Application by DS Smith Paper Limited for the Kemsley Mill K4 Combined Heat and Power Generating Station

The Examining Authority's Second Written Questions and Requests for Information (ExQ2) with Environment Agency responses.

Appendix 5.3: Stack Height Determination

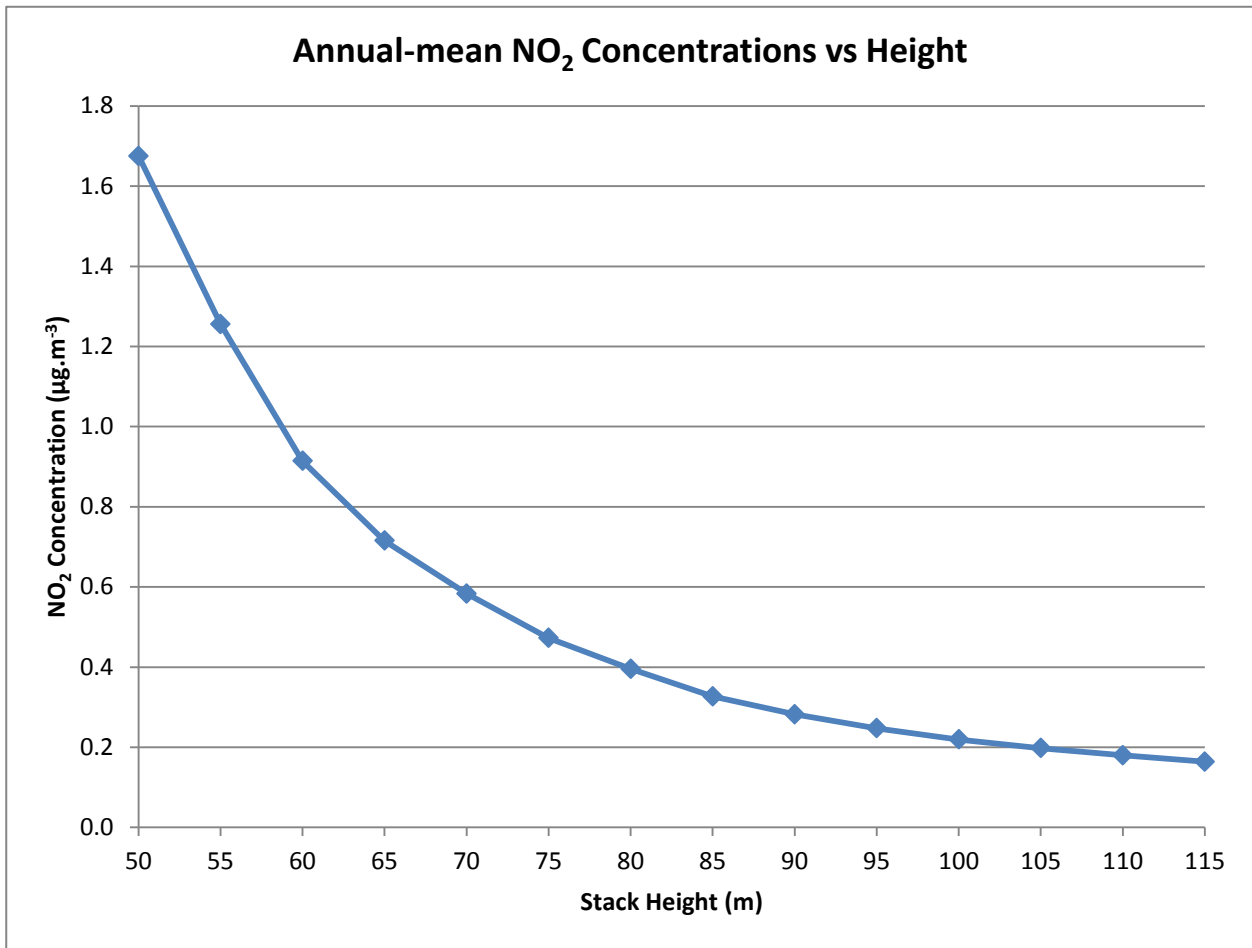
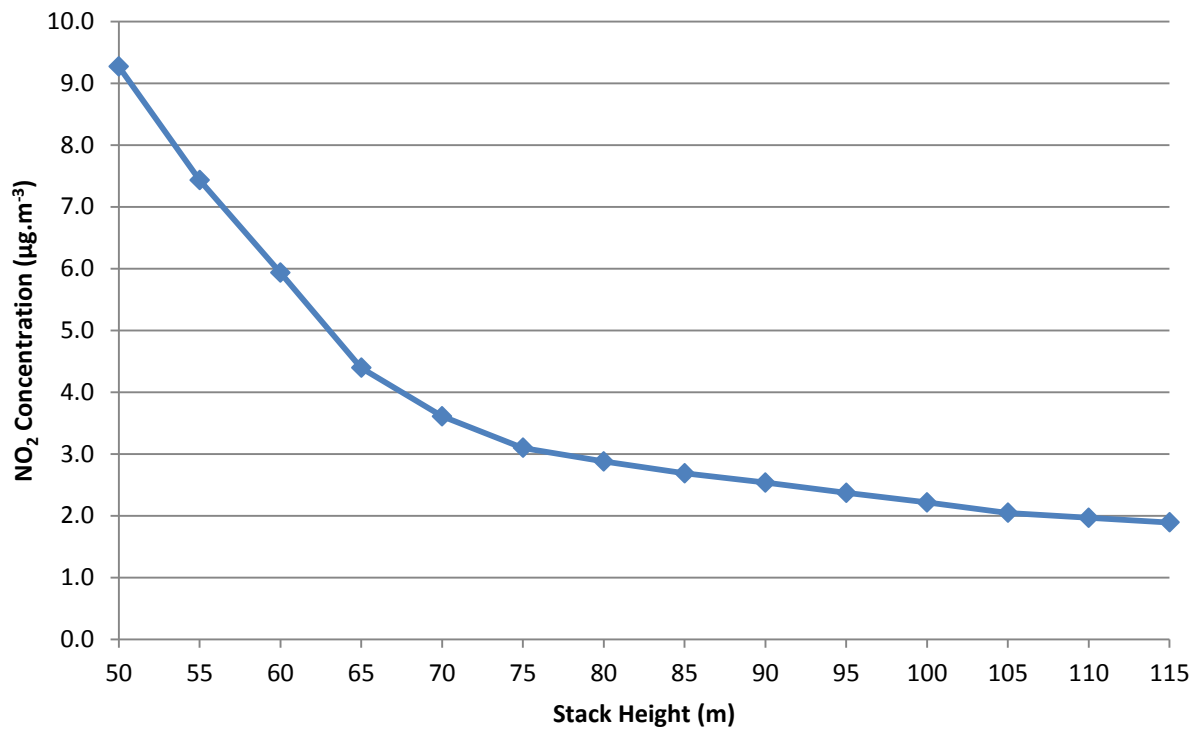
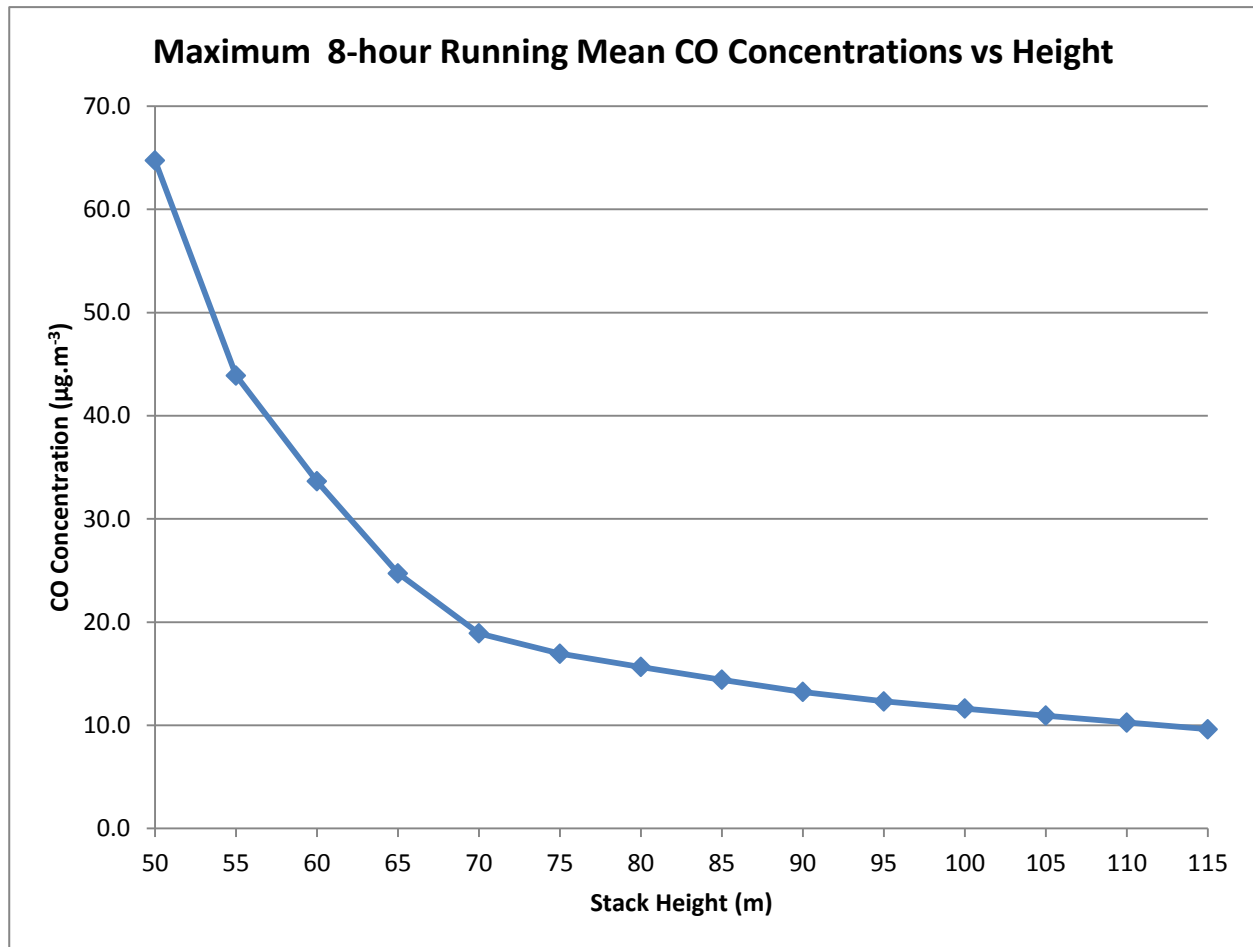
<p>Q2.2.1</p>	<p>Environment Agency</p>	<p>The Applicant's Post Deadline 4 Covering Letter [AS-019] confirms that the height of the HRSG Stack would be between 70m AOD and 73m AOD. The ES has assessed a 70m stack. AS-019 goes on to state that typically increasing stack height has beneficial effects on ambient air quality and that the flexibility sought would not result in any materially new or different effects on air quality than those in the submitted ES but would in any event be pursuant to meeting the tests of the permitting regulations.</p> <p>Do the Environment Agency (EA) and Natural England (NE) wish to comment on the Applicant's statement about air quality effects including effects on ecology, taking account of the EA's response to Q1.1.8 [REP2-032]?</p> <p>ANSWER: The Environment Agency has not made a detailed review of the proposed additional contributions of additional air pollutants which would form part of our assessment of the Environmental Permit Application. It is anticipated overall mass emissions of NOx (as the principle pollutant of concern) from a power plant supporting paper production will decrease. Effective stack height allows the appropriate dispersion of pollutants to secure reduced ground level concentrations for both deposition on habitats sites and local air quality. The Environment Agency cannot predetermine our EPR assessment which will include a detailed audit of the applicant's model. Due to the modern nature of the technology proposed it is likely any requirement for reduced NOx contributions would come from stack height increases. Whilst none (NOx concentration reductions) have been predicted to date, however the Environment Agency is aware of additional proposals for an additional incineration line (Wheelabrator Kemsley North) to be located adjacent to the "K3" facility at the Kemsley Paper Mill. We understand the Planning Inspectorate will have been in discussion with Wheelabrator Technologies to discuss how this additional project fits into the "K3" Development Consent Order.</p> <p>If the concern is over amenity impacts of Stack Height, we would note there are higher stack present at the current CHP facility, at the K3 facility and in the area of Ridham Dock.</p> <p>The applicant has proposed twin tracking of the EPR application. Where we are able to we will share the results of our assessment of the applicant model with the Inspectorate. At this stage it would be beneficial to progress the applicant's proposals with some flexibility when considering stack height.</p>
